Application Ref:	3/2025/0922				Ribble Valley Borough Council www.ribblevalley.gov.uk
Date Inspected:	22/5/26	Site Notice:	1/5/26		
Officer:	BT				
DELEGATED ITEM FILE REPORT:				REFUSAL

Development Description:	Change of use from agricultural building to single residential self-build dwelling and associated residential curtilage together with hardstanding/parking.
Site Address/Location:	Land at Pendleton Road, Wiswell, BB7 9BZ.

PROPOSED SITE PLAN. SCALE 1:500

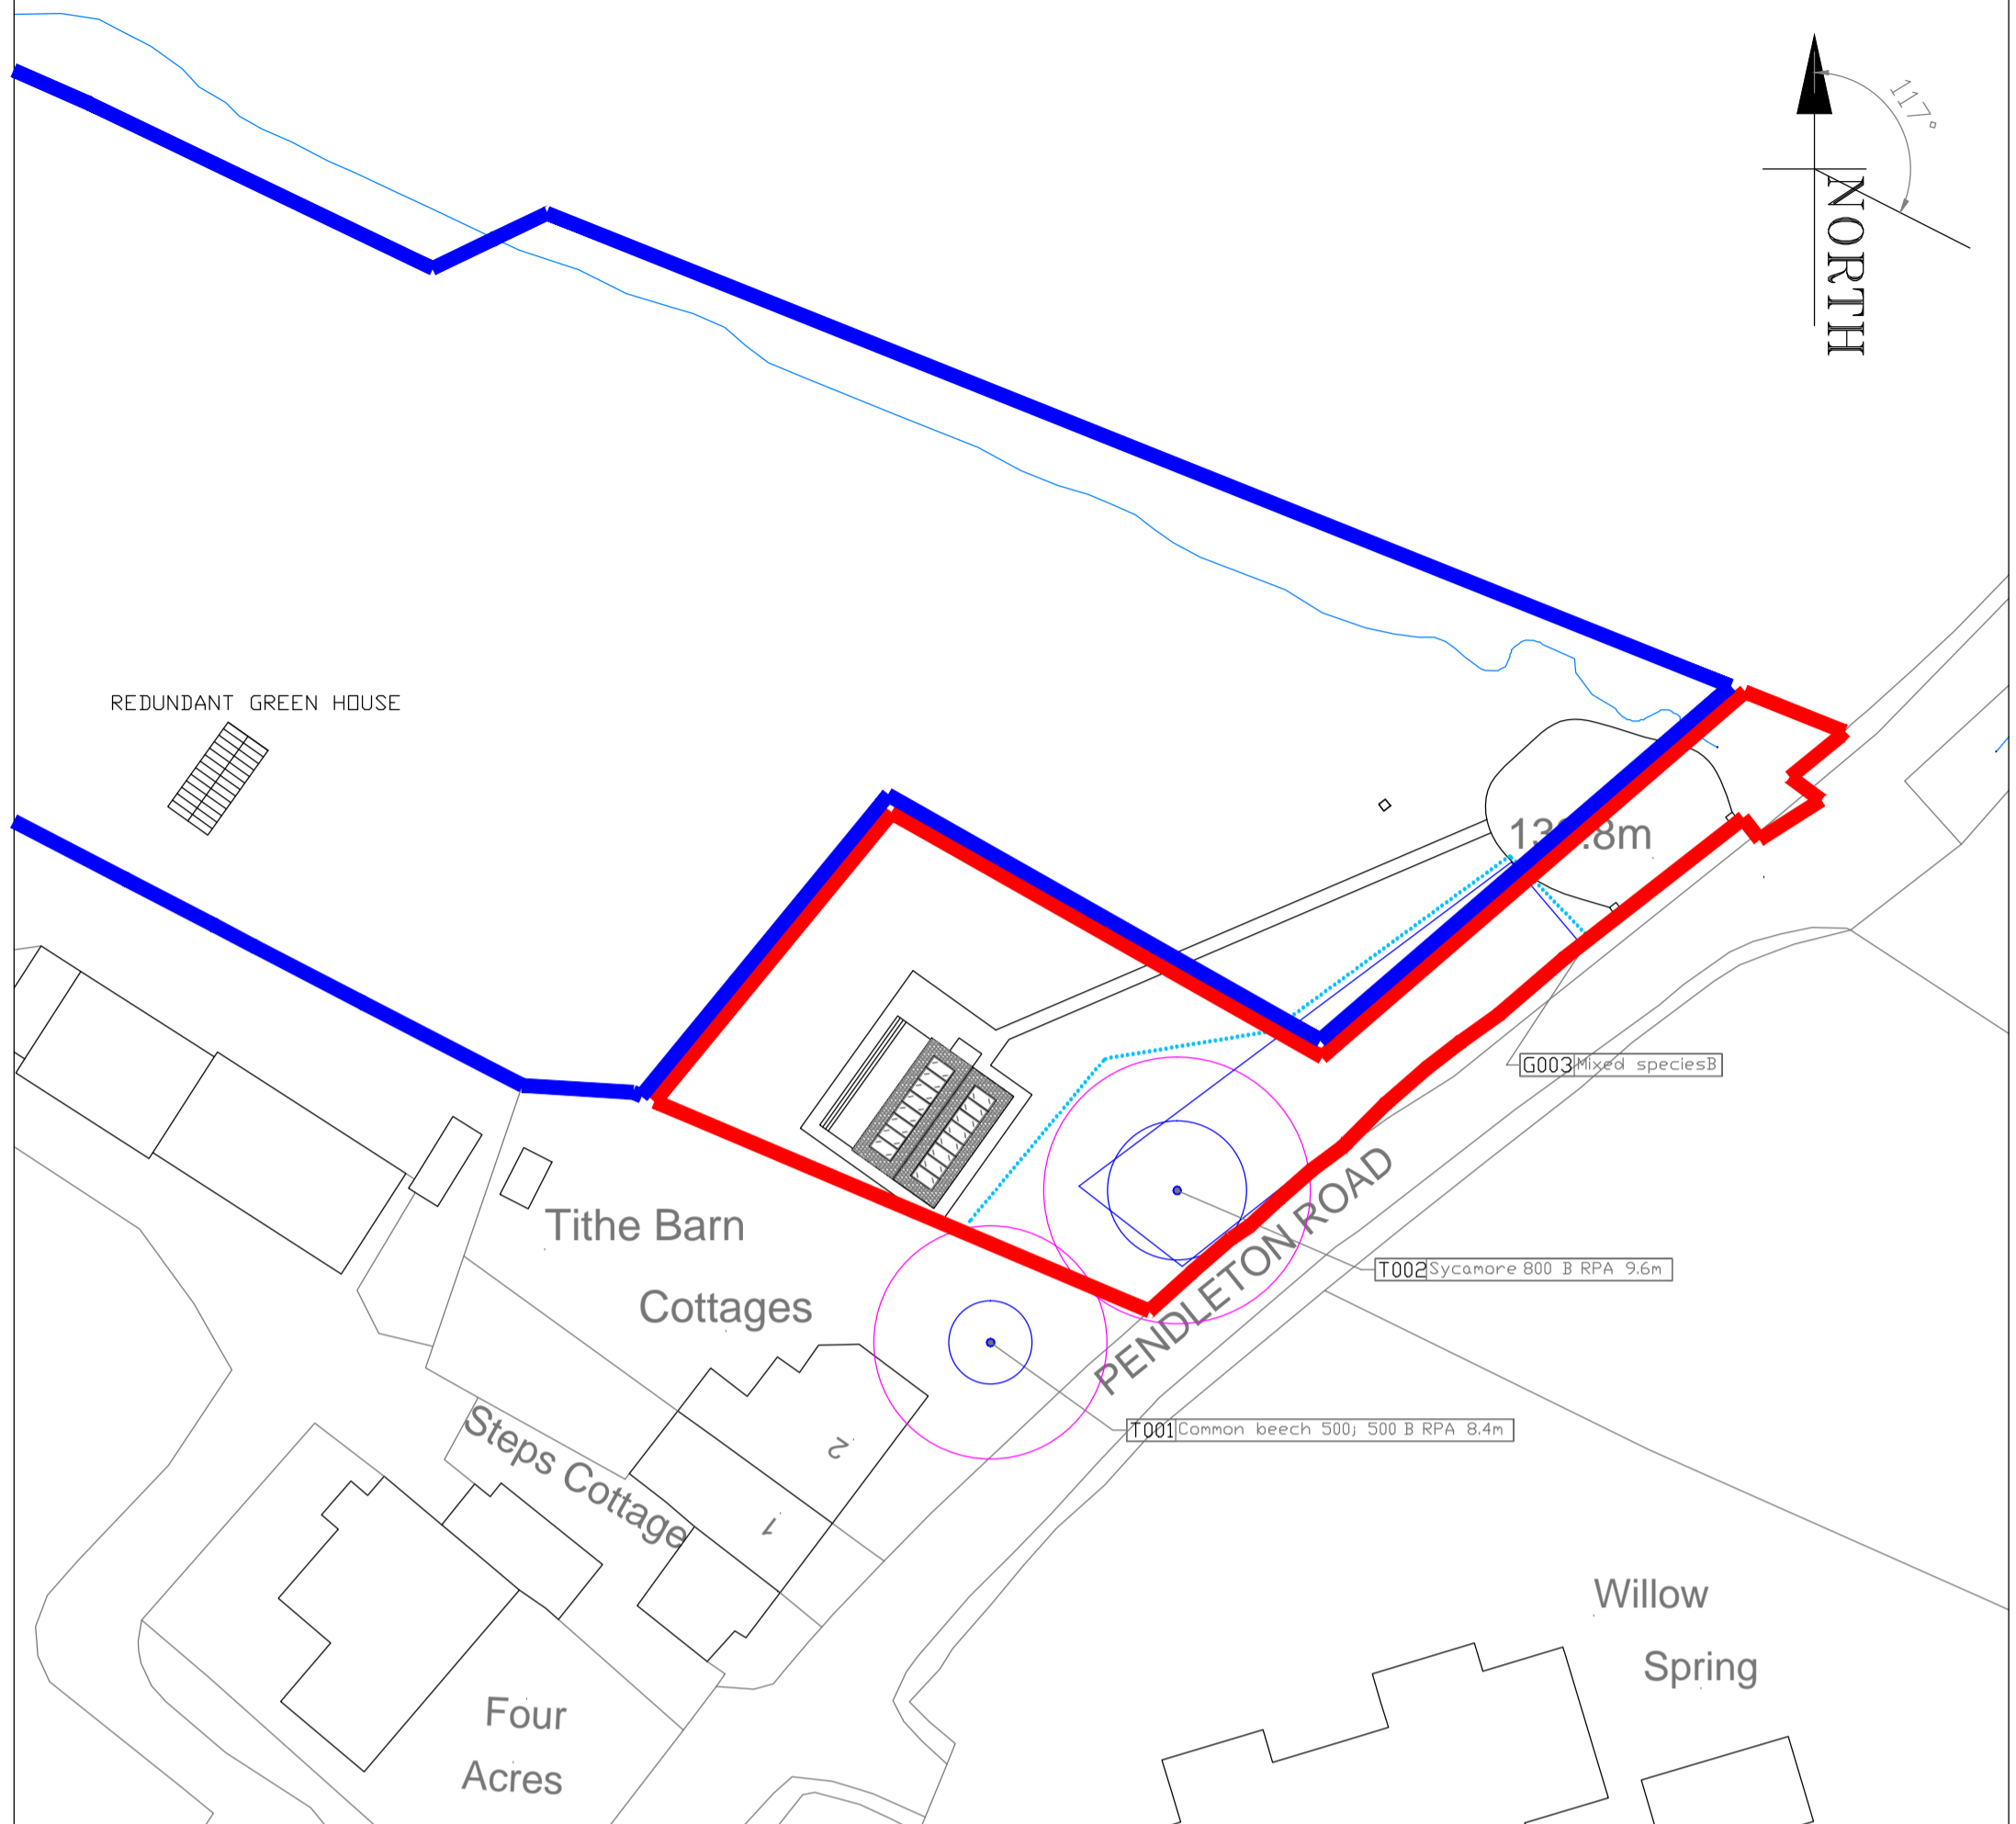
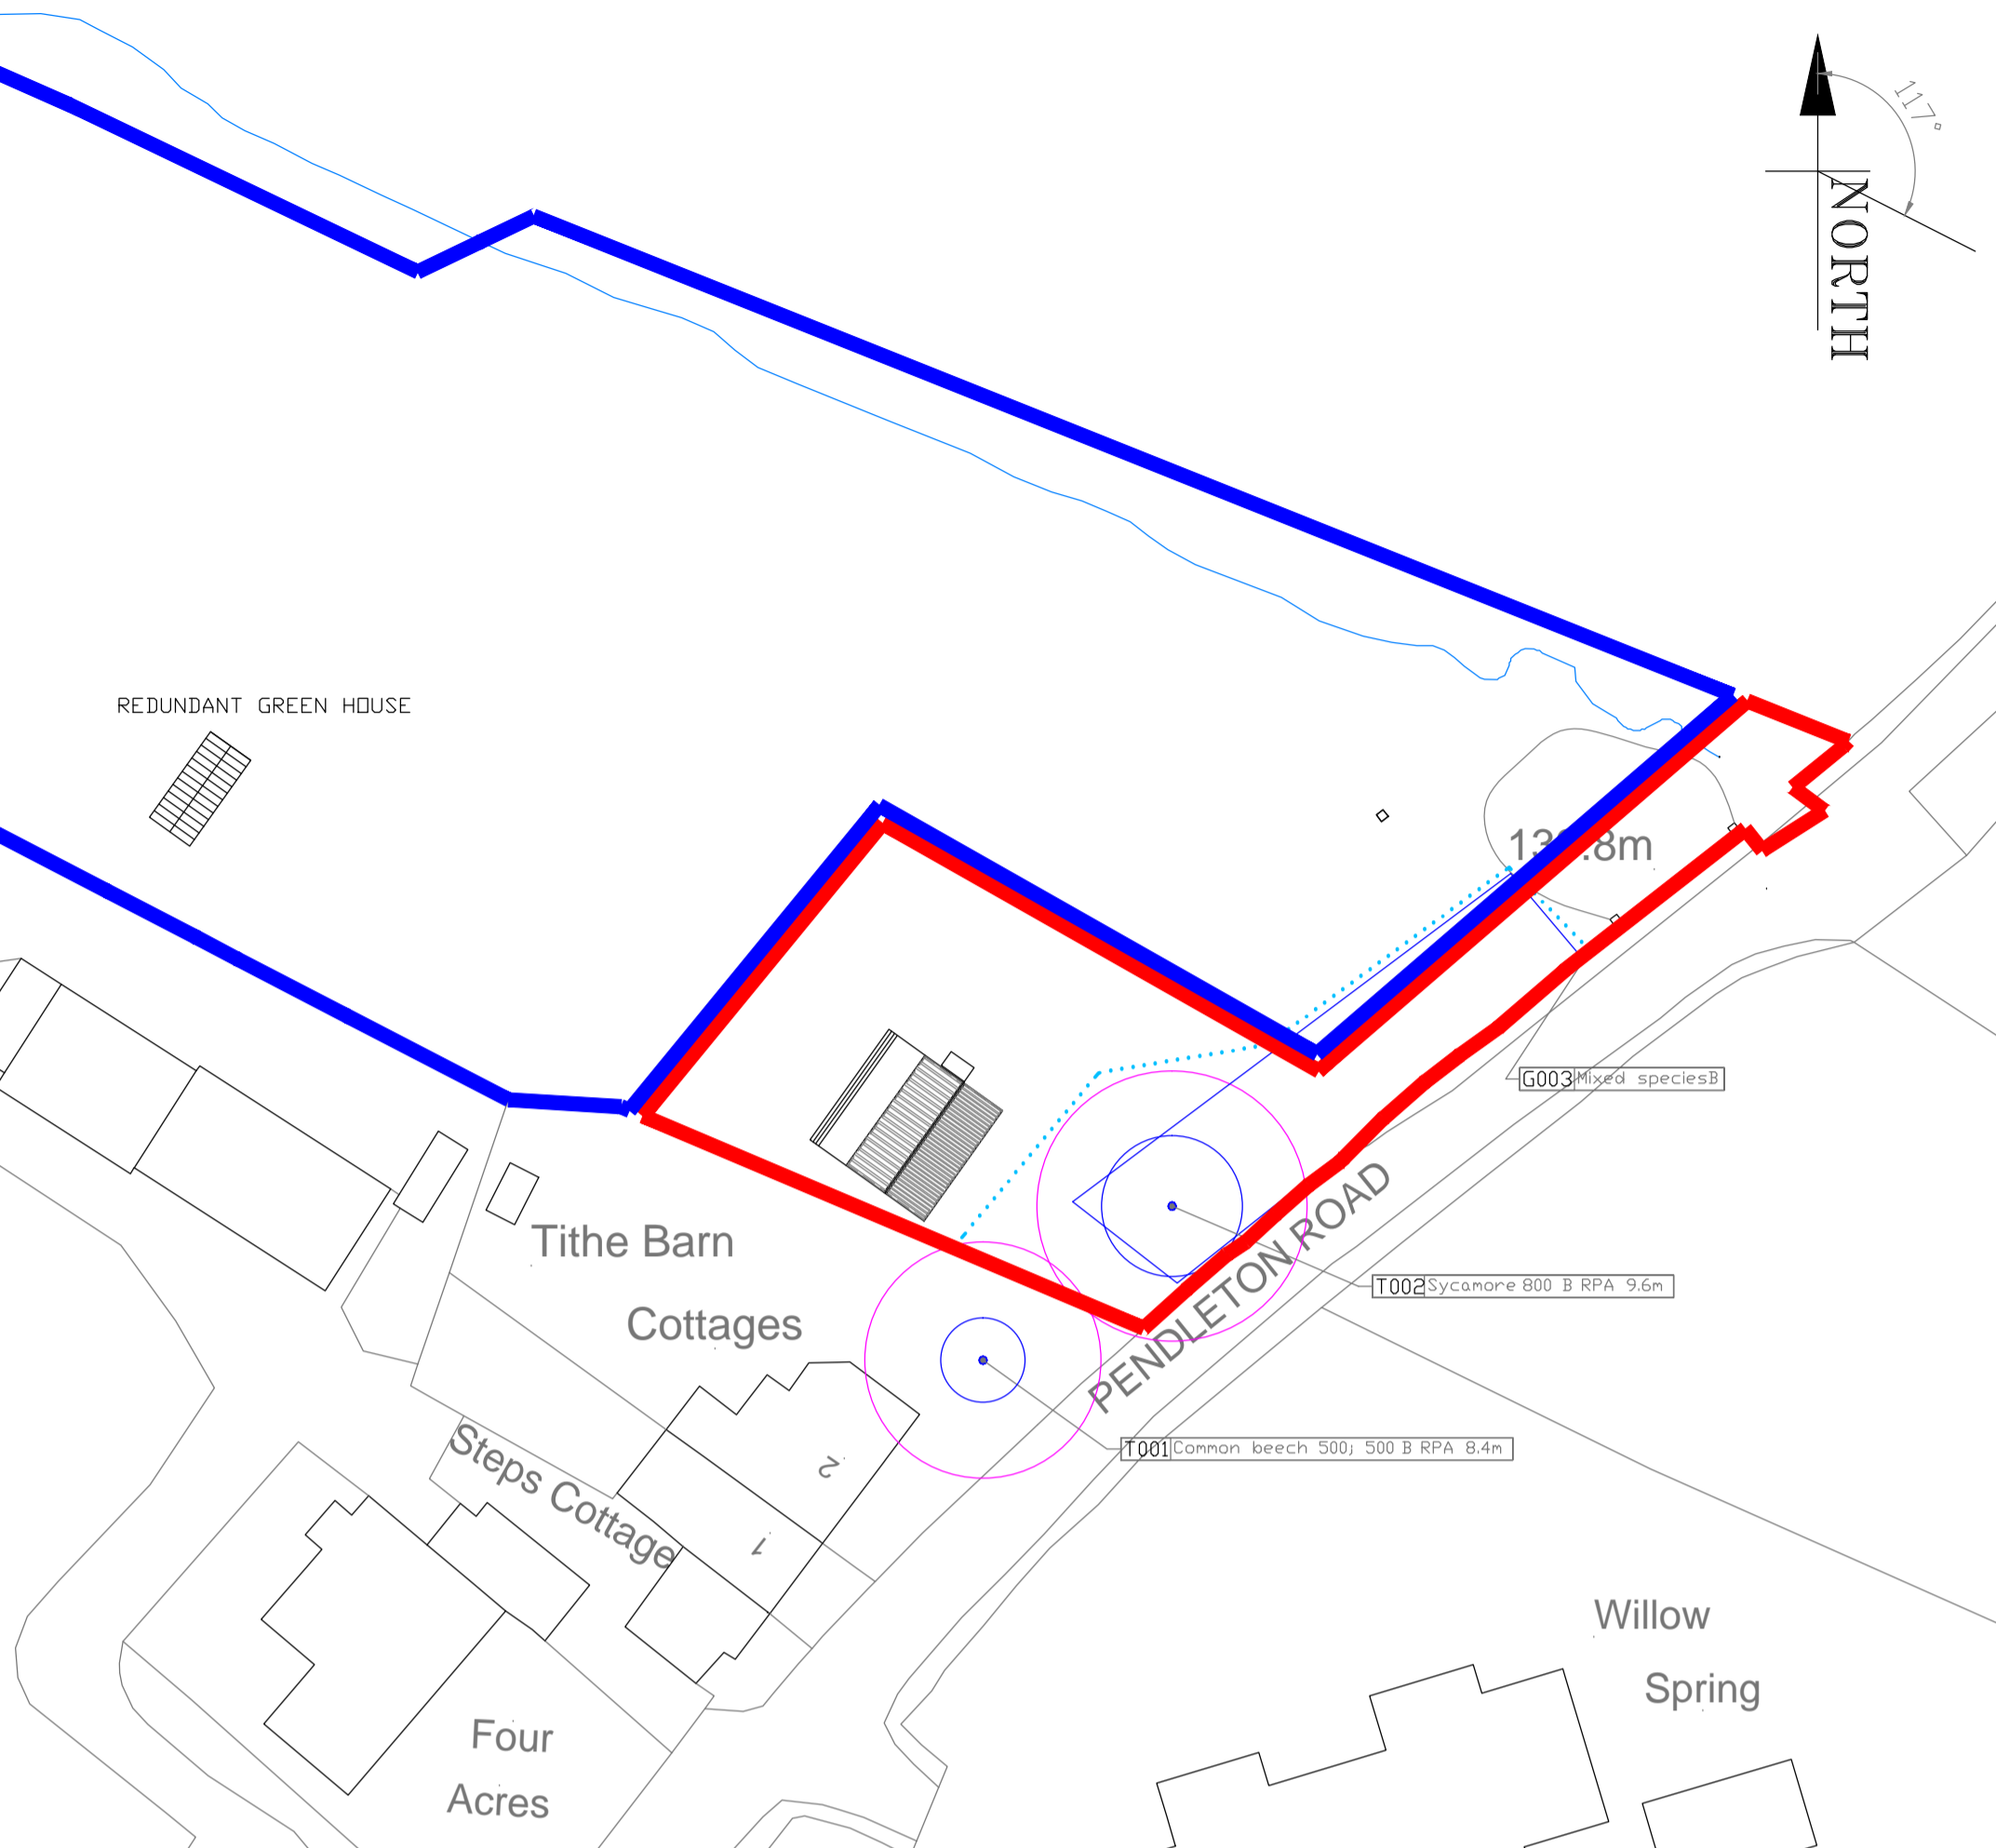
Consequently, the proposed development, by virtue of the overtly domestic alterations proposed to the existing building along with the introduction of a driveway, footpath, hardstanding, terraced steps and retention of the existing metal housing unit would amount to an incongruous and unsympathetic form of development which would have a harmful urbanising impact upon the visual amenities of the application site and surrounding area. The proposal would therefore fail to satisfy the requirements of Paragraphs 135 (c) of the NPPF and Policies DMG1 of the Core Strategy.

| 02: | The proposed development, by virtue of the overtly domestic alterations proposed to the existing building along with the introduction of a driveway, footpath, hardstanding, terraced steps and retention of the existing metal housing unit would amount to an incongruous and unsympathetic form of development which would have a harmful urbanising impact upon the visual amenities of the application site and surrounding area. The proposal would therefore fail to satisfy the requirements of Paragraphs 135 (c) of the National Planning Policy Framework and Policies DMG1 and DMG2 of the Ribble Valley Core Strategy. |
